Your Ref: OWPC660
Our Ref: AW/146/13/T 24-06-2013
Please ask for:
Mrs J Chapman

Town & Country Planning Act 1990 (as amended)
Town & Country Planning (Tree Preservation) (England) Regulations 2012

Reduce the crowns of 2 No Field Maple trees by 4 metres.
Ditch to the rear of 23 Fernhurst Gardens Aldwick

SKETCH.

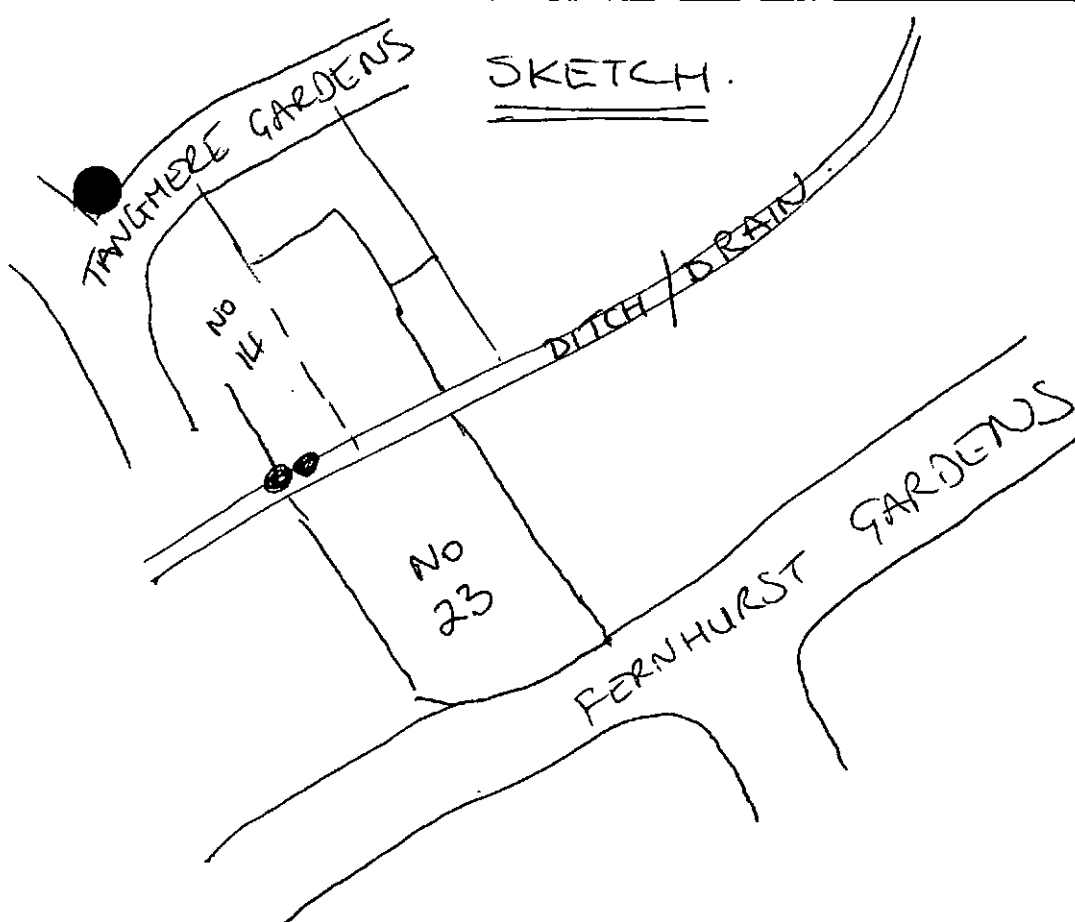
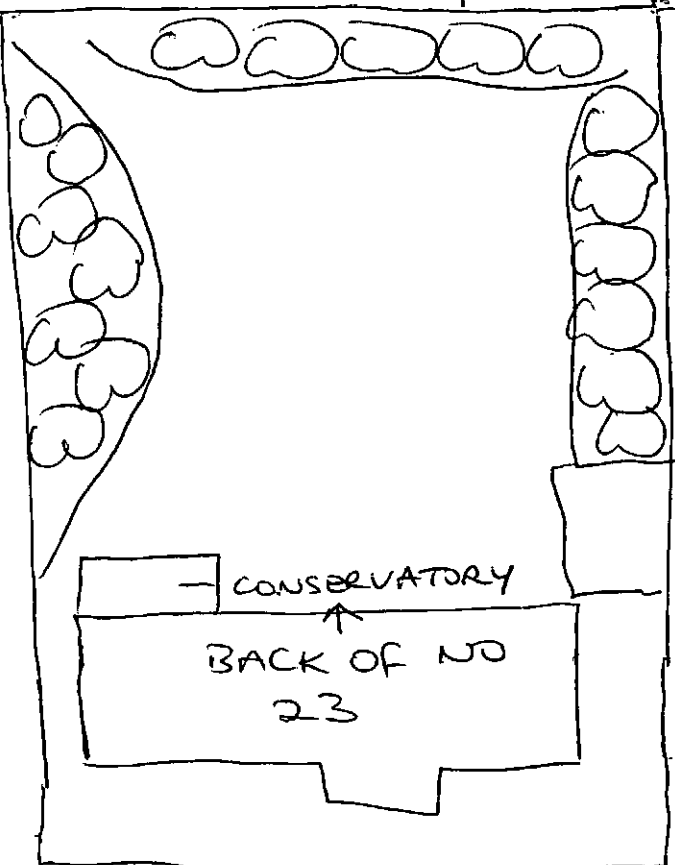
I looked at the sketch in the application, (held by Aldwick Council, not on the website) which equates 4 metres with bringing the crown down to the roof line. From my own estimation the roof line is more than 4 metres from the top of the tree.
